**Gunlake Quarries
Gunlake Quarry Project**

**ENVIRONMENTAL ASSESSMENT
RESPONSE TO SUBMISSIONS**

MAY 2008

APPENDIX 5
WATER CYCLE MANAGEMENT

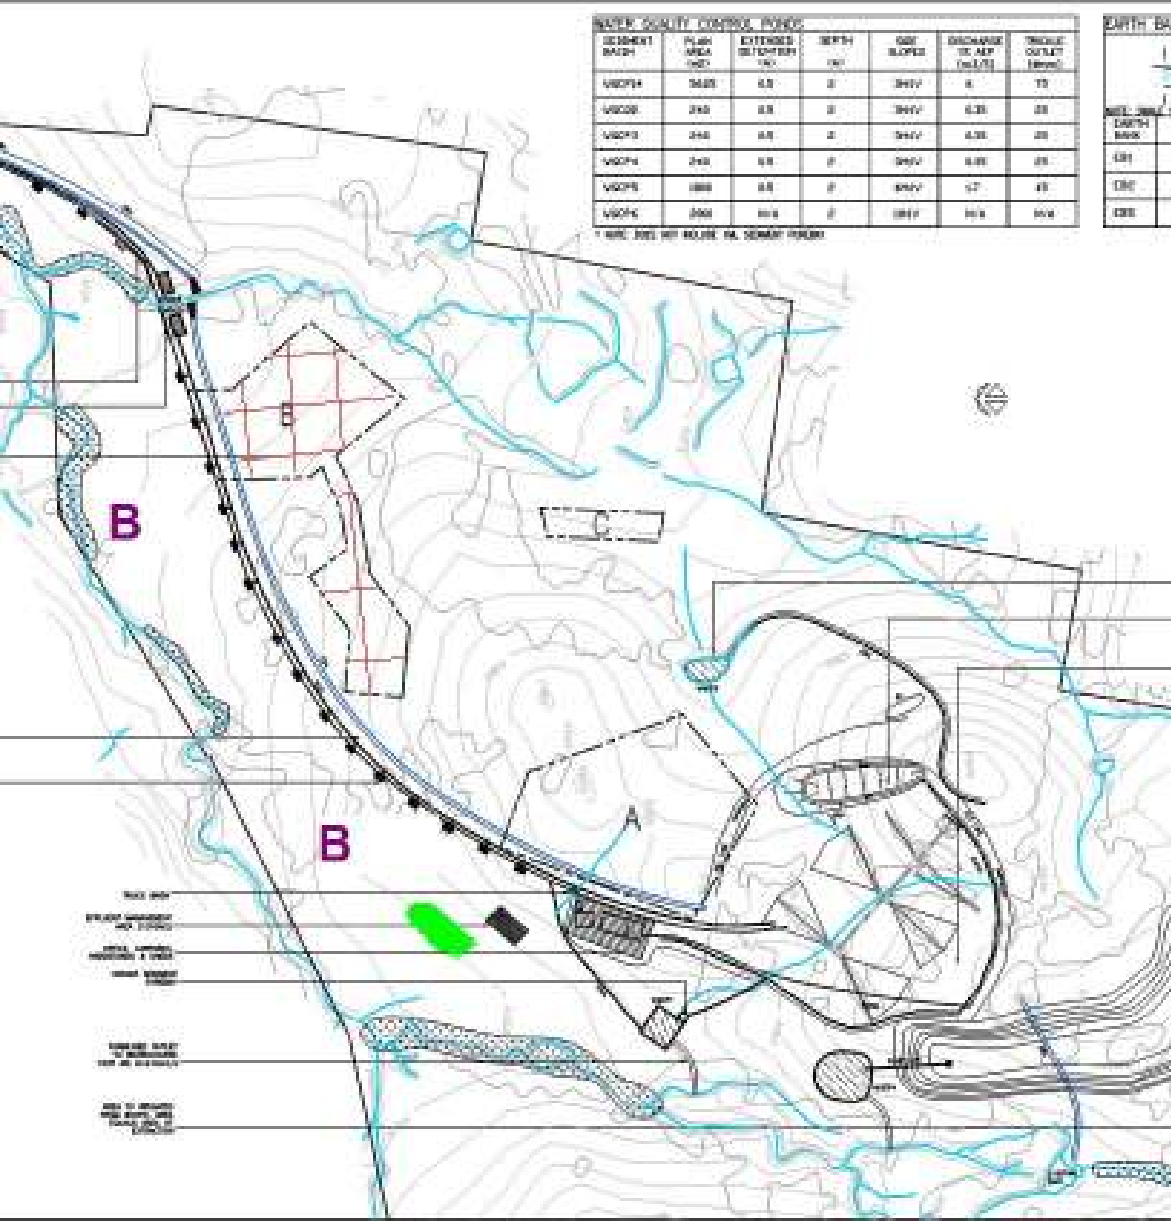
1.9 DECC requested more information of the impact of the development on endangered ecological communities. Reference was made to disturbing 8.8ha of these communities	DECC	Gunlake modified the layout of the irrigation area and reduced the area affected to 4.19ha. This matter has been addressed by Ecotone Ecological Consultants and included as Appendix III in the Gunlake Quarries Report, "Response to DECC Comments" dated 12 th March 2008. A copy of the Heggies Report is included as Appendix III of this response document (Refer to Section "Endangered Ecological Communities" in the 12 th March Report). This Section also highlights proposed fencing off of areas of these communities and the establishment of off-set areas for ongoing conservation of the community.
